**TO:** Nell Donaldson, Planner  
**FROM:** David Senus, P.E. & Ashley Auger, E.I.T.  
**DATE:** December 9, 2014  
**RE:** Brighton Ave Hotel Redevelopment, Preliminary Level III Site Plan Application

Woodard & Curran has reviewed the Preliminary Level III Site Plan Application for the proposed hotel redevelopment project located at 1210 Brighton Avenue in Portland, Maine. The project involves the demolition of an existing 135 room motel and the construction of a new 86 room hotel, parking lot, and utilities.

- Preliminary Level III Site Plan Application and attachments, dated November 14, 2014, prepared by Walsh Engineering Associates, Inc., on behalf of Portland Hotels, Inc.
- Engineering Plans, Sheets S1.0, C1.0, C2.0, C3.0, L1.1, C4.0, C4.1, C4.2, C4.3, C4.4, D1.0, & D2.0, dated November 14, 2014, prepared by Walsh Engineering Associates, Inc., on behalf of Portland Hotels, Inc.

7 TYPICAL PIPE TRENCHING DETAIL
C4.1 NOT TO SCALE

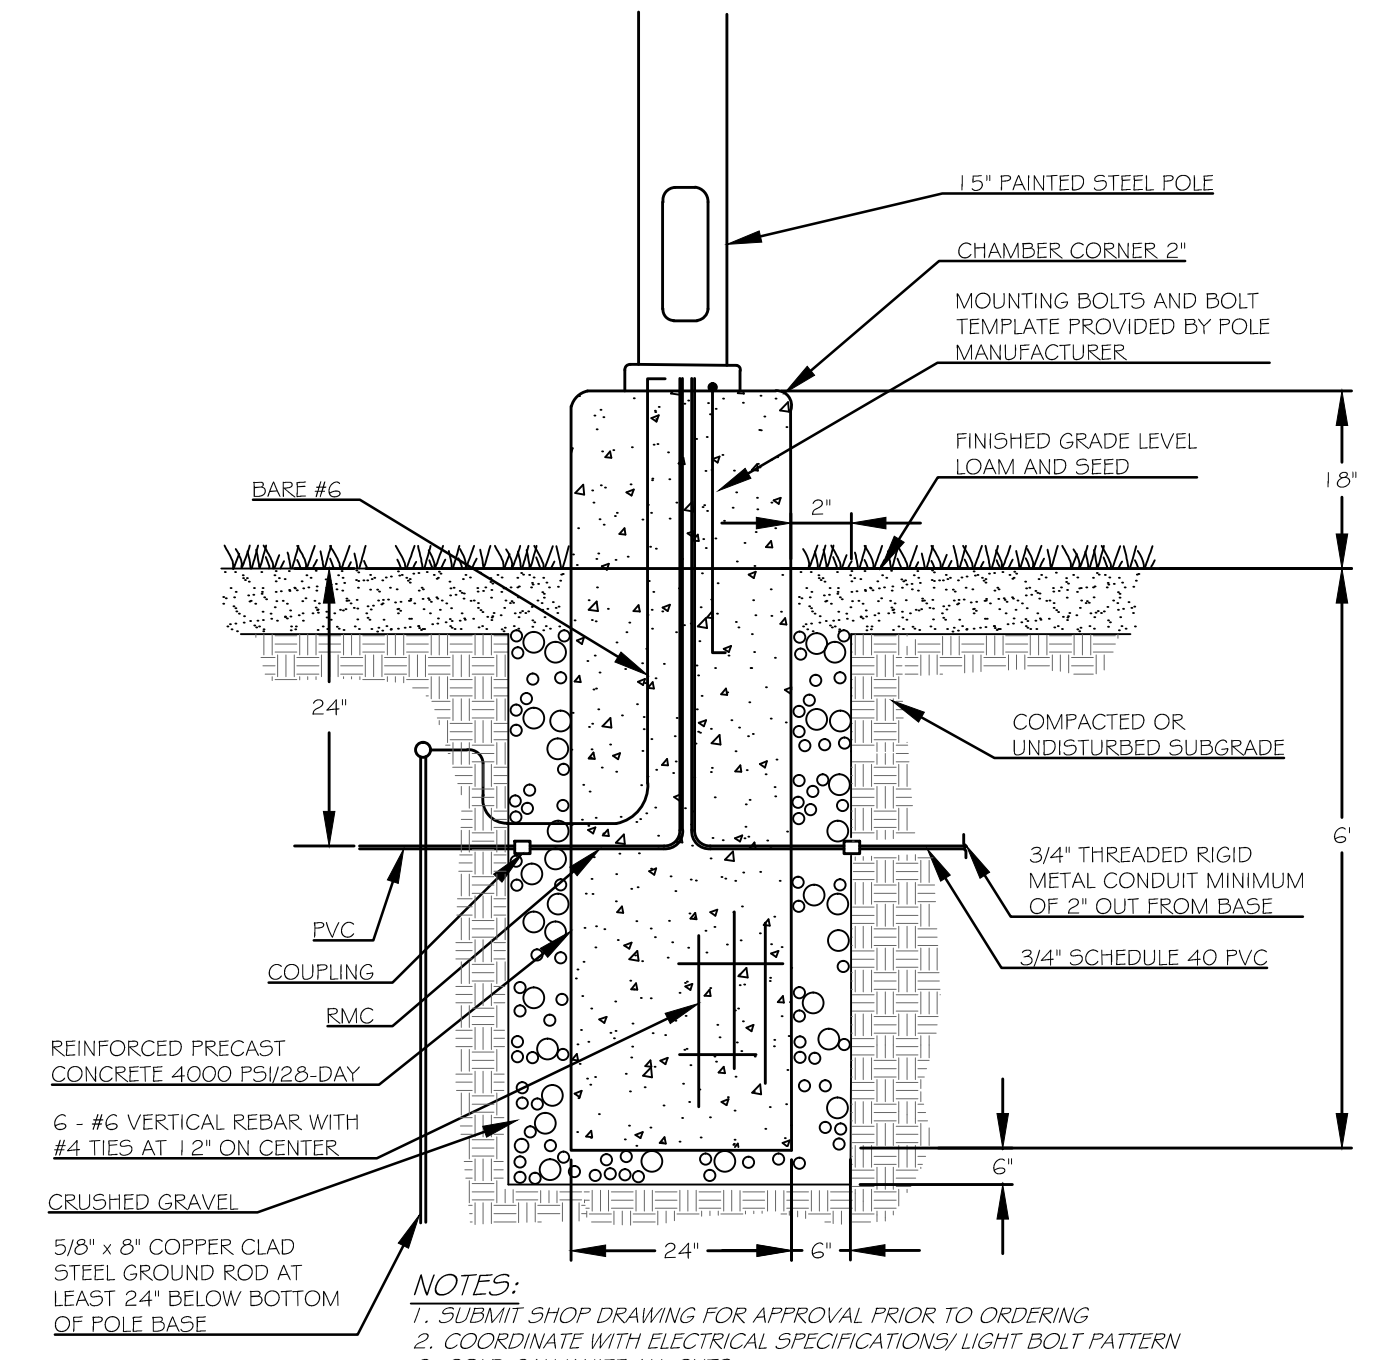
- 7) The Applicant should provide a detail for trench work within the City Right-of-Way in accordance with Figure II-12 of the City of Portland Technical Manual.

3 ALLAN BLOCK RETAINING WALL
C4.5 NOT TO SCALE

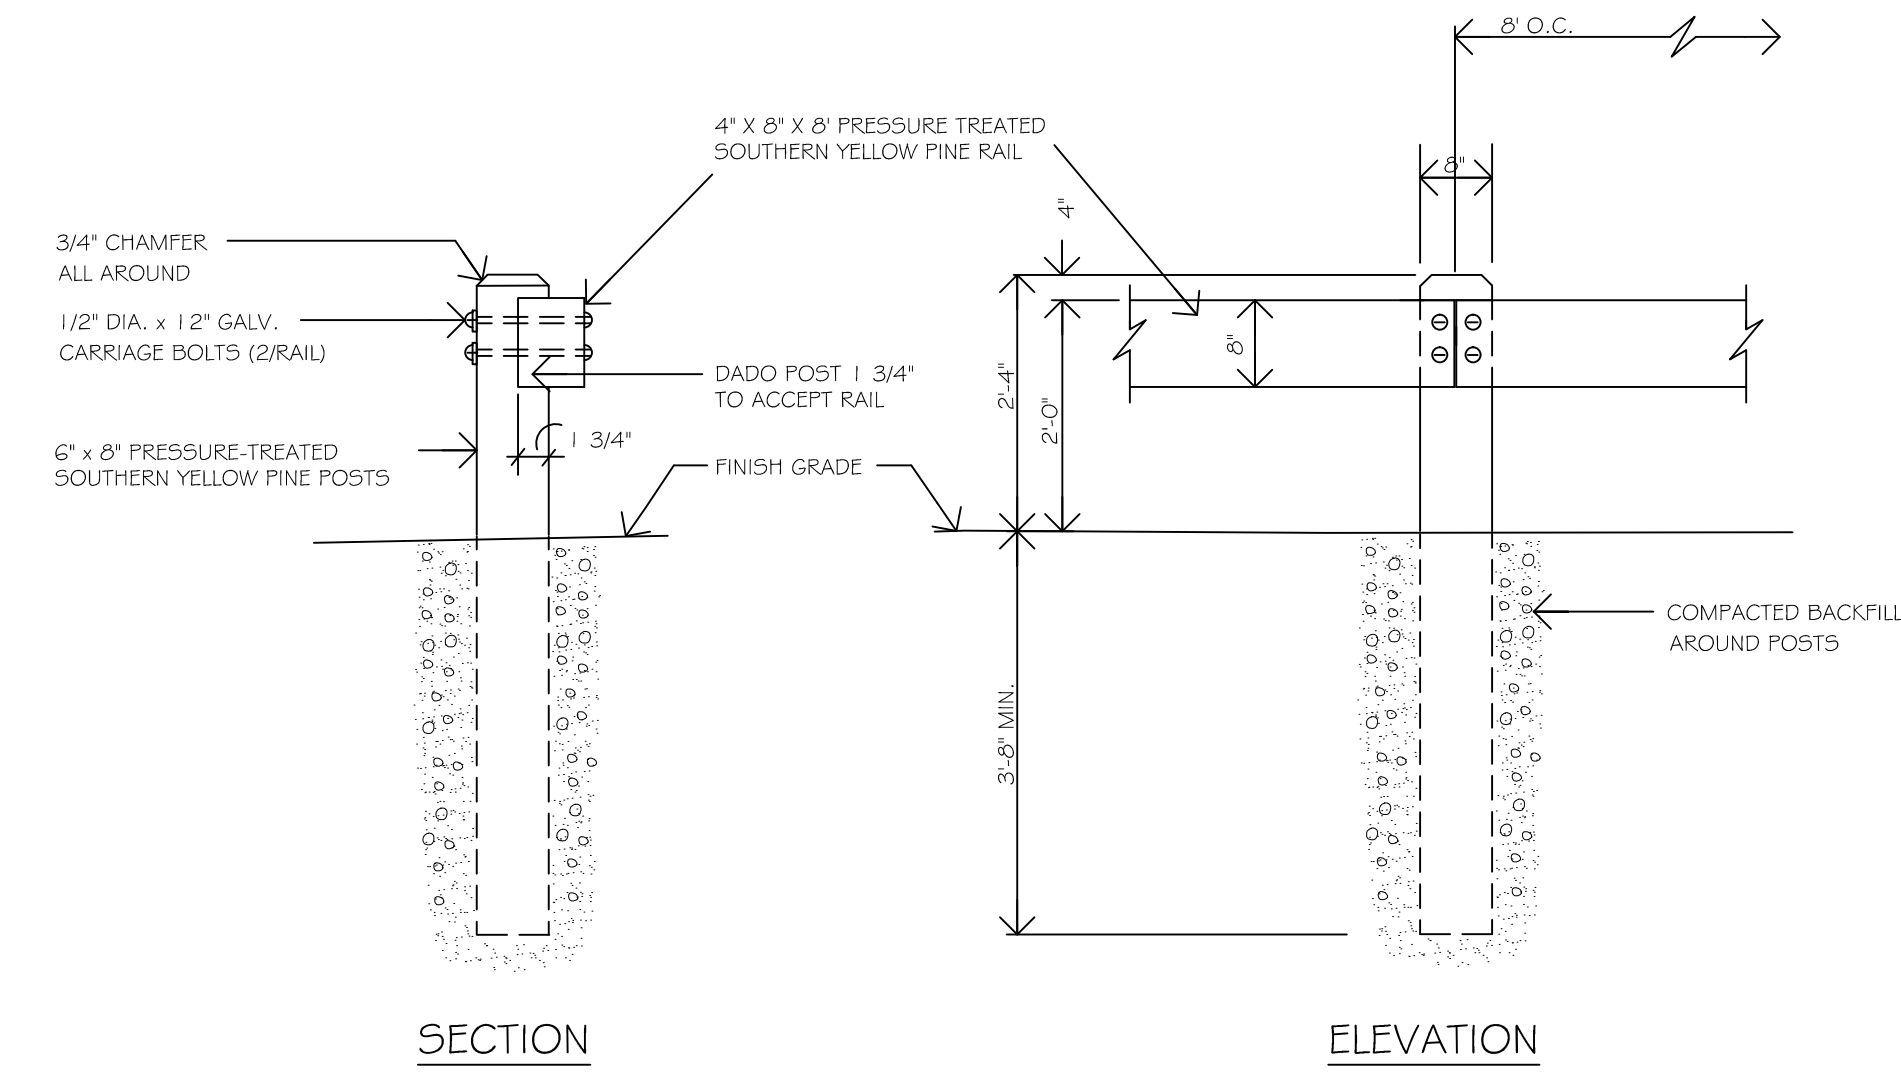
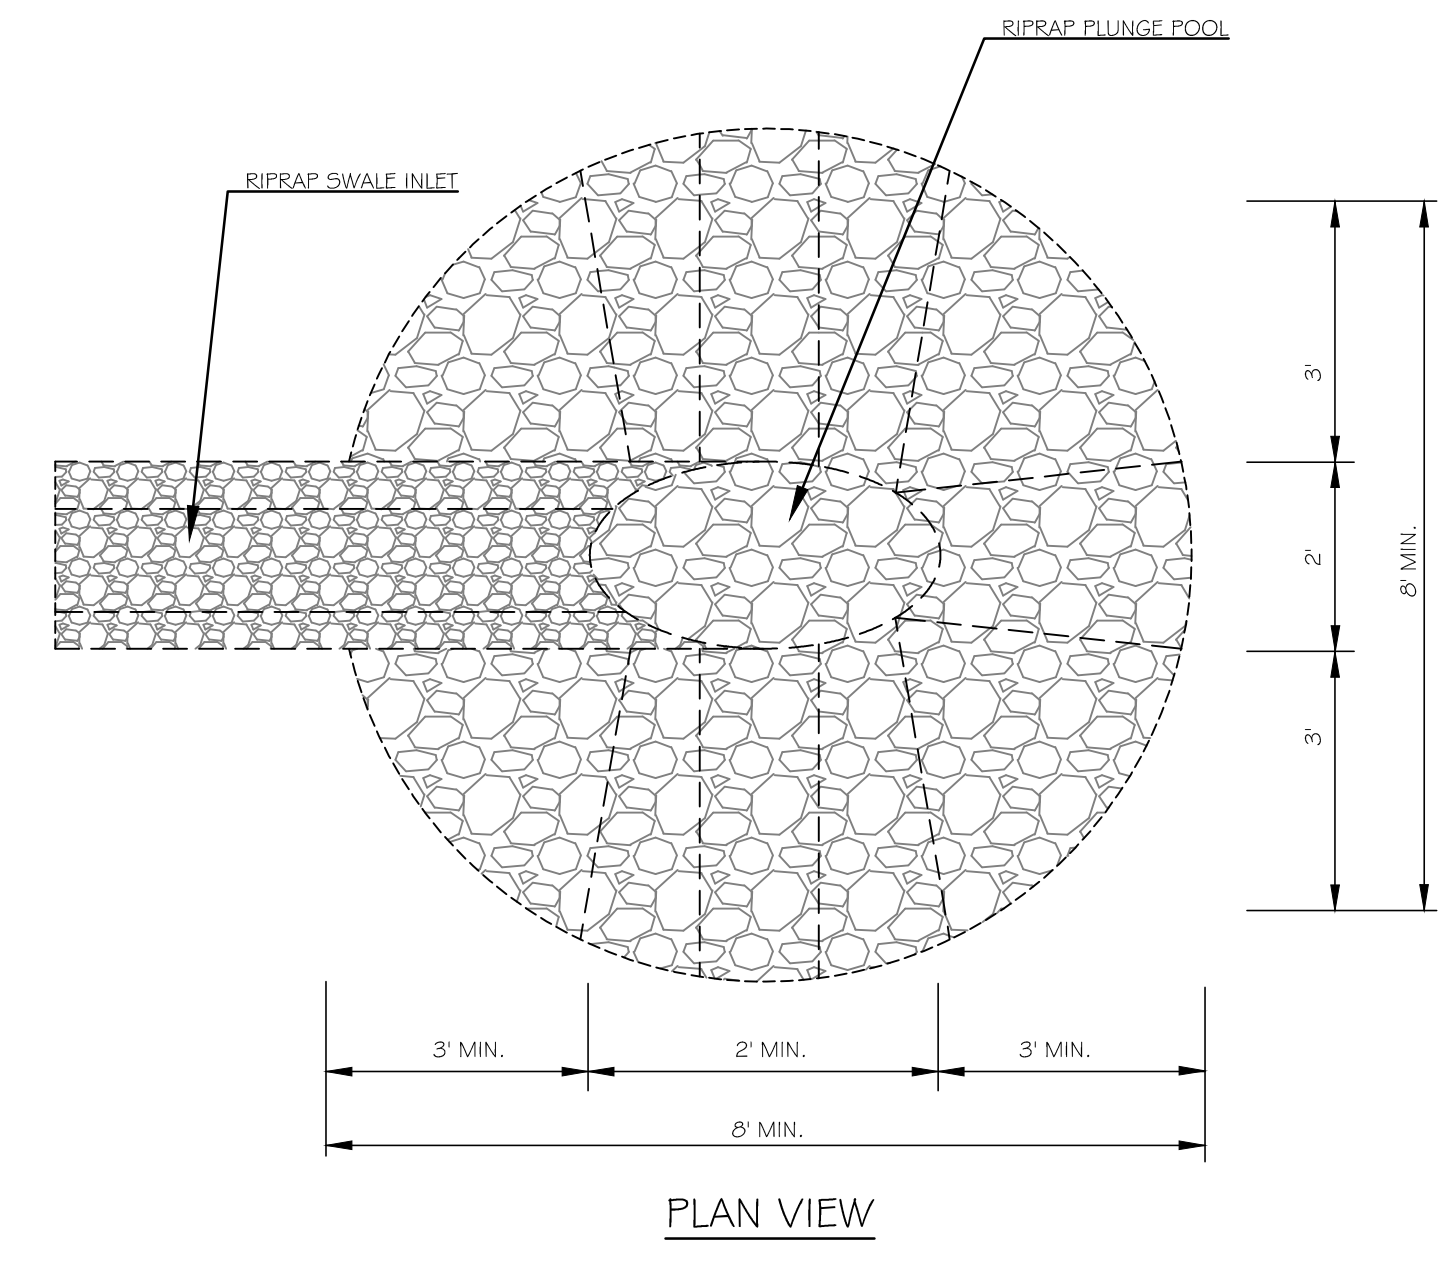
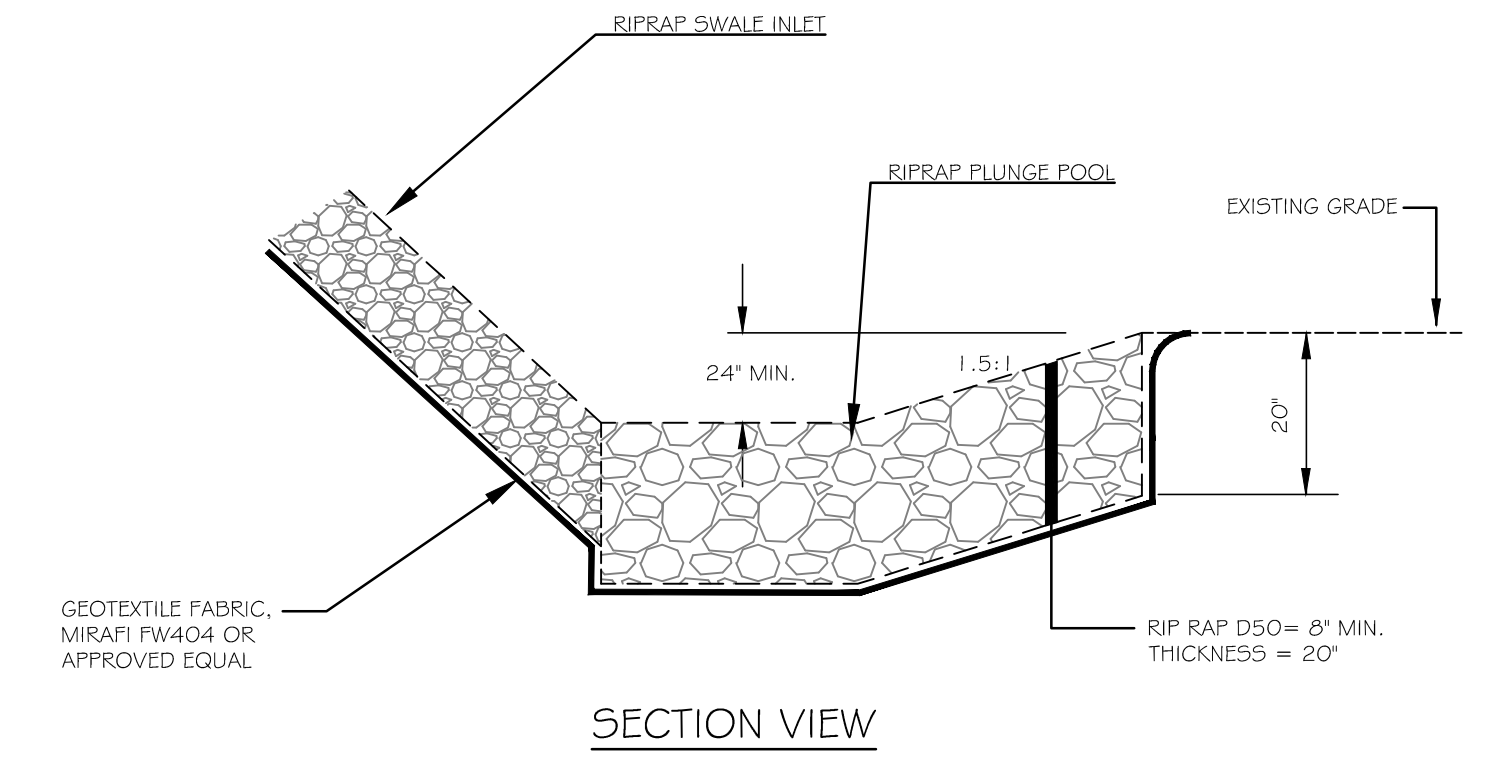
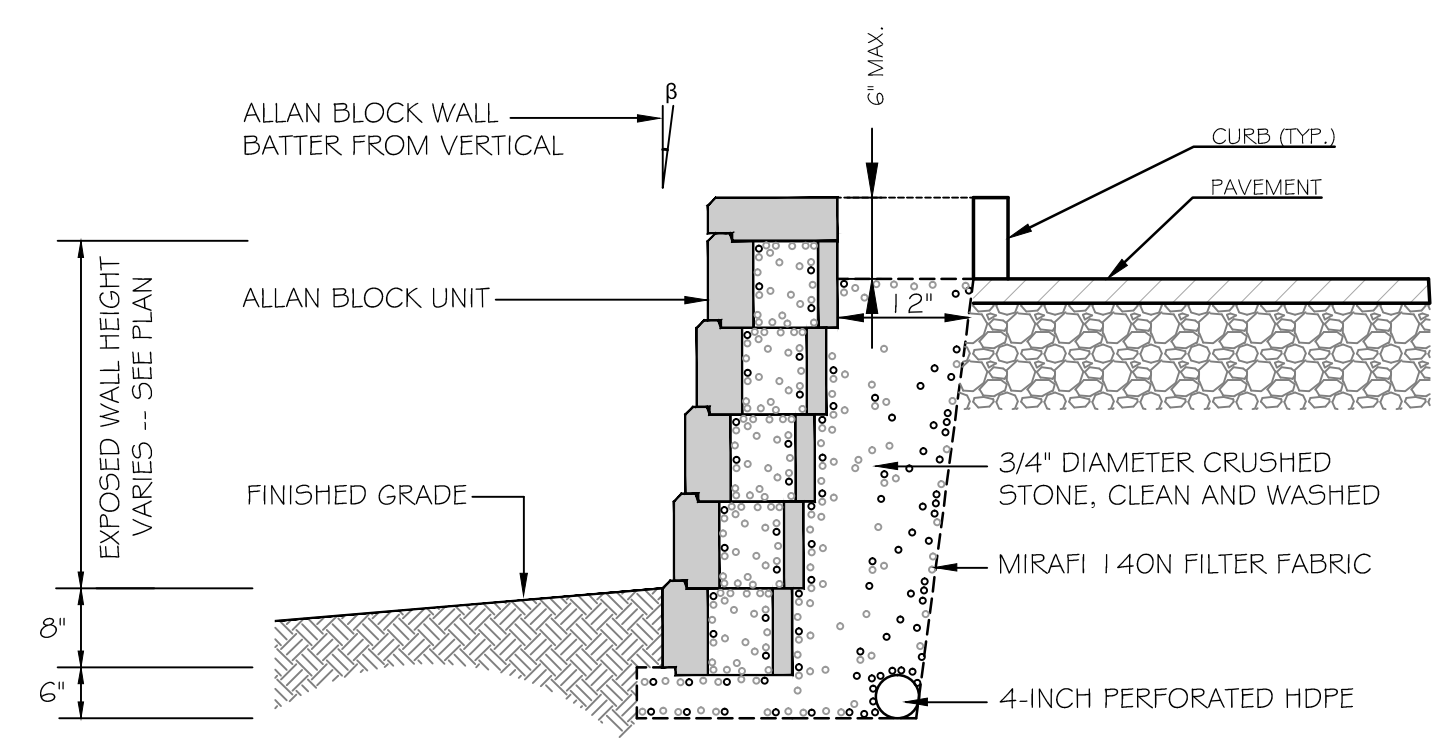
- 8) The Applicant should provide details for the proposed retaining walls and riprap aprons.
